**The Woodland Trust**  
Kempton Way  
Grantham  
Lincolnshire  
NG31 6LL

**Reference: A66 Northern Trans-Pennine Project**

The proposed scheme will result in likely detrimental impact to two areas of ancient woodland as outlined in the consultation documents. Our concerns focus on the Temple Sowerby to Appleby and Cross Lanes to Rokeby sections of the scheme, which are likely to affect the following ancient woodlands:

Map Title
 Figure 6.2
 Ancient Woodland, Ancient Tree Inventory
 and Habitats of Priority Importance
 Scheme: 08, Cross Lanes to Rokeby
 Sheet 8 of 10

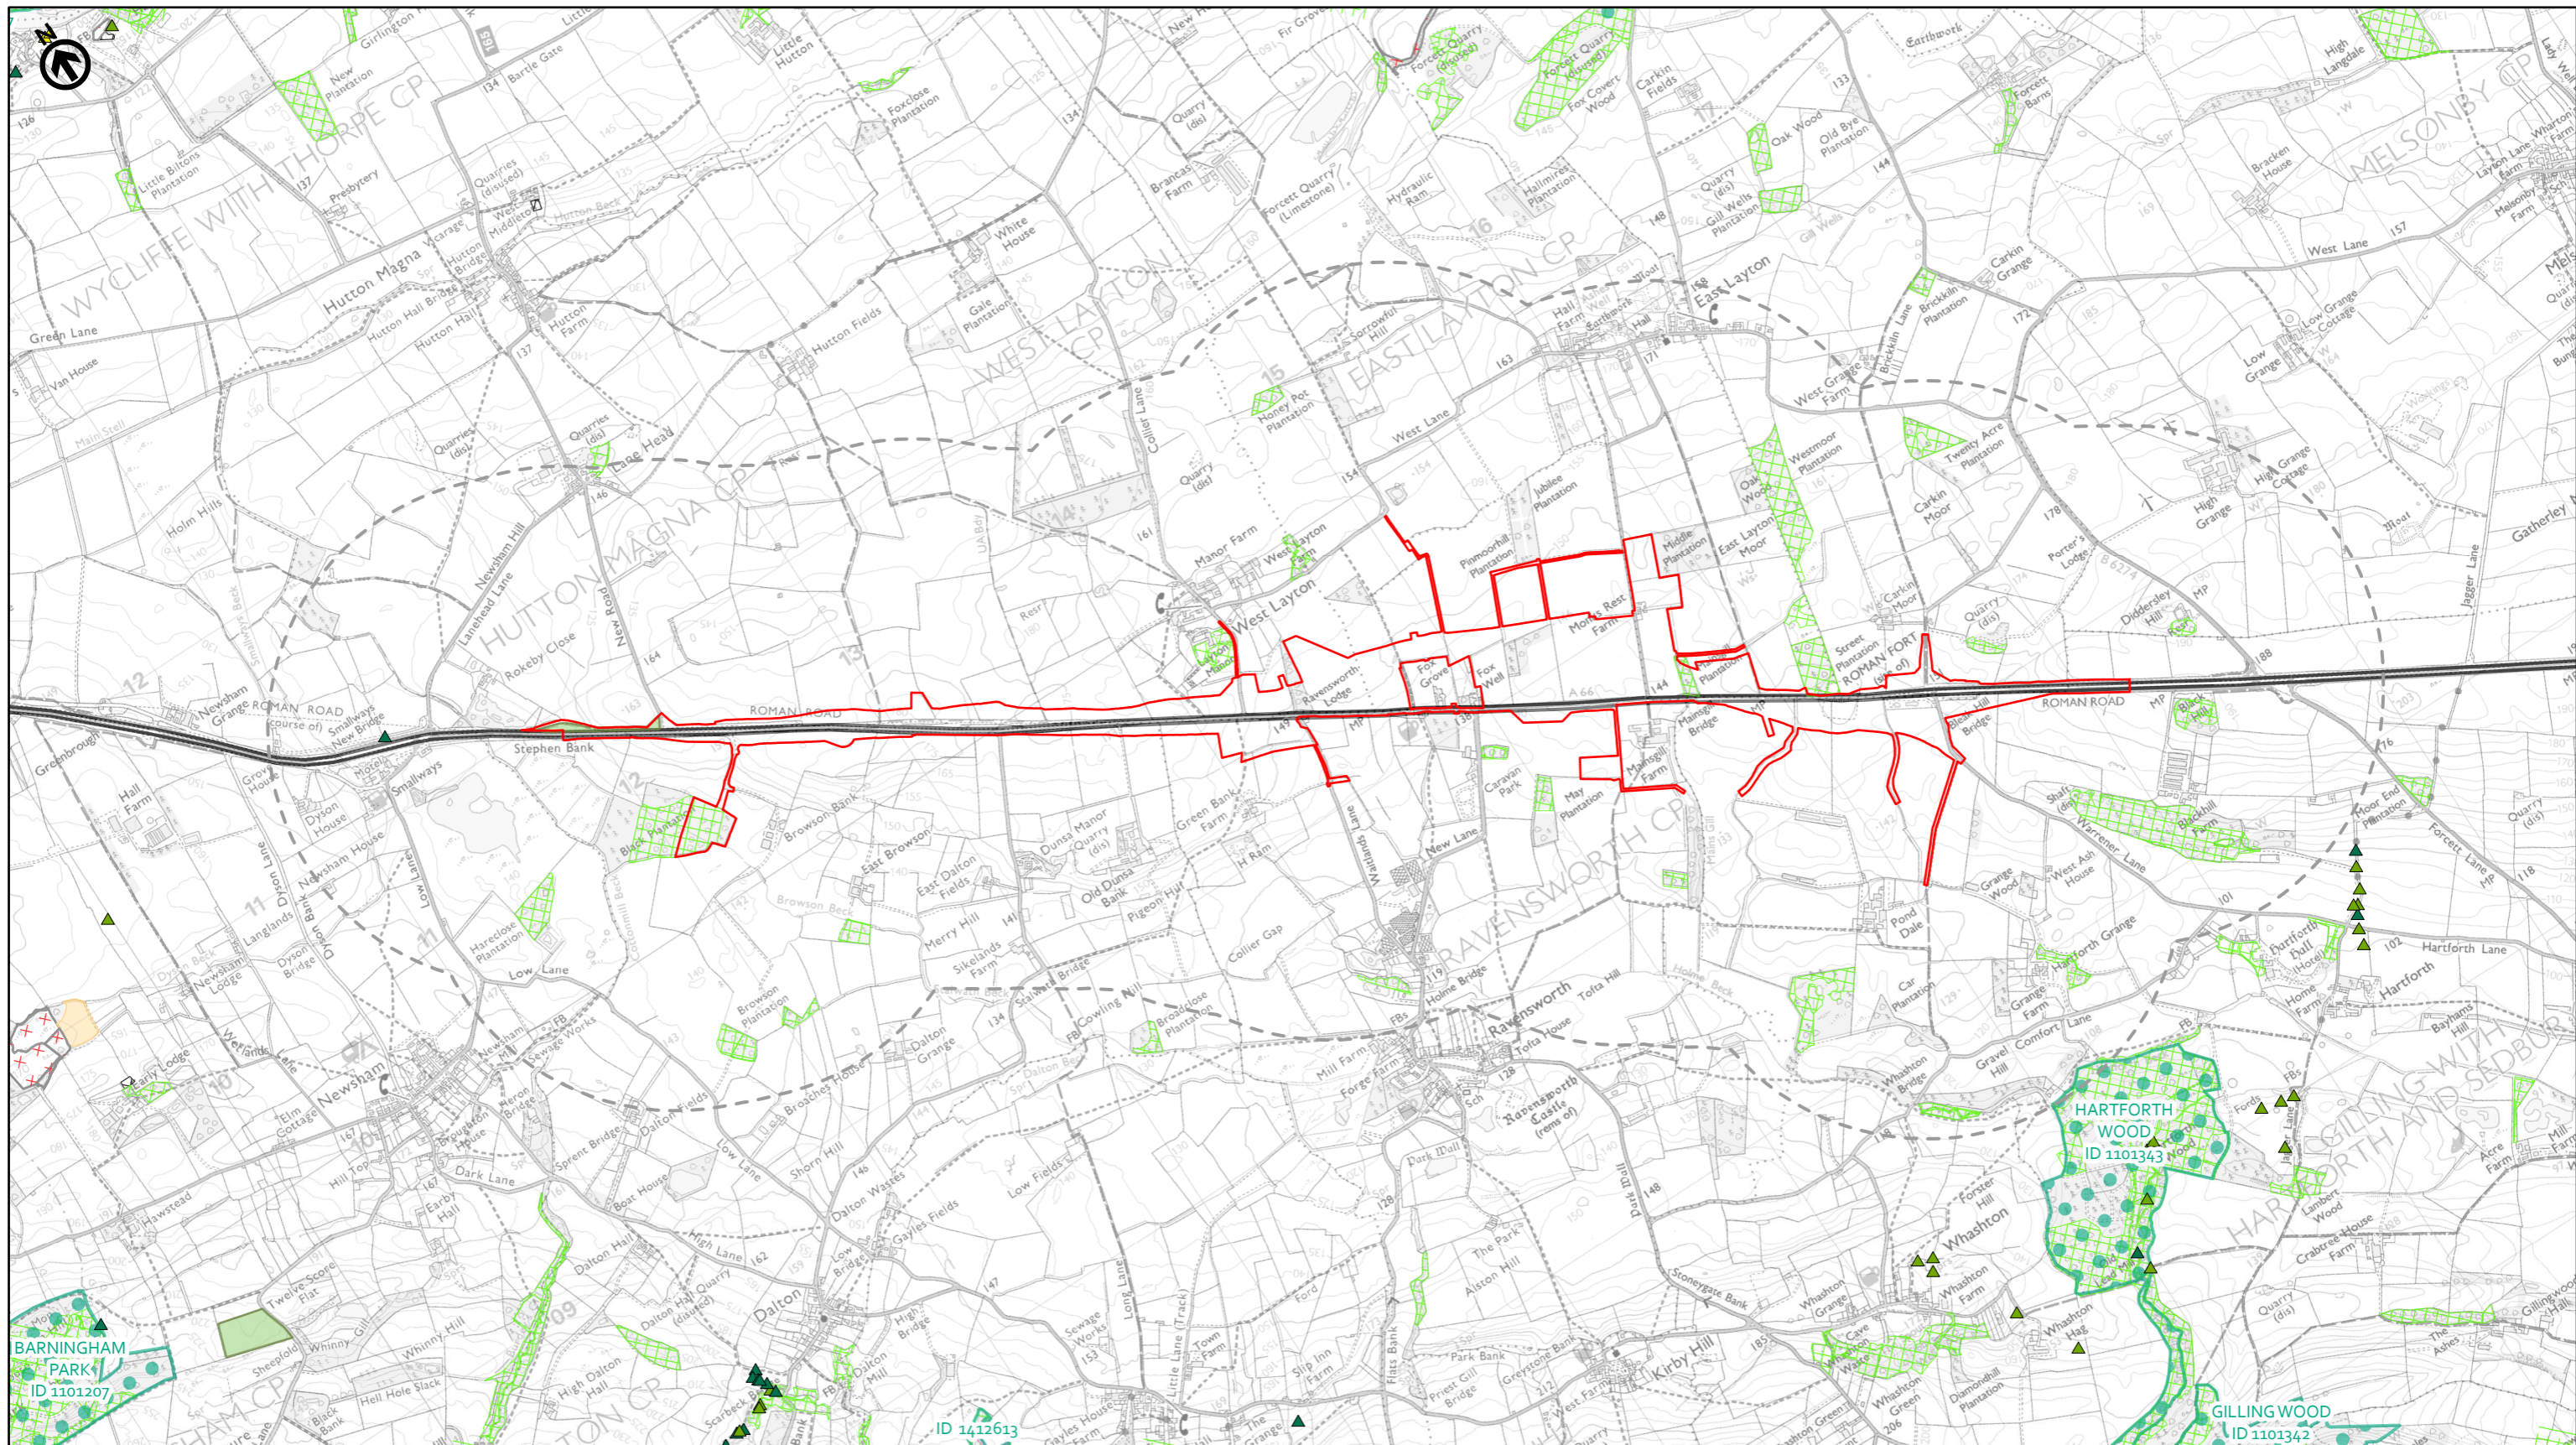
The proposed scheme is predicted to result in likely detrimental impact to Jack Wood from the proximity of the new Rokeby Junction and to Chapel Wood during upgrade works to the existing A66. In addition, Chapter 5 of the Environmental Statement outlines the potential for nitrogen deposition to several ancient woodlands within the wider scheme area (5.10.65).

We are concerned about potential detrimental impact to both Jack Wood and Chapel Wood from their proximity to the proposed carriageway alignment. Whilst we acknowledge that Chapel Wood is sited adjacent to the existing A66, the close proximity of the dual carriageway will lead to numerous adverse impacts such as increased noise and light pollution from traffic, as well as dust pollution during construction of the proposal.

We consider that the proposed Rokeby Junction should be re-configured to ensure that a **30m** buffer zone can be provided to Jack Wood. This is to alleviate impacts such as dust, noise and light pollution, run-off containing pollutants, as well as to avoid damage to tree roots.

The 30m buffer zone should be kept free of development unless the proposed works would aid in further alleviating impacts on the ancient woodland, i.e., in the form of barriers, fencing, bunds, or embankments. In the case of the aforementioned features, it is important that such works remain 15m away from the ancient woodland, not only to prevent impacts on the root systems of the trees that make up the woodland edge, but also to prevent other indirect impacts associated with construction works. To this end, we recommend that the buffer zone is planted prior to construction, to create a phased habitat to the ancient woodland that absorbs the indirect impacts occurring during the construction and operational phase.
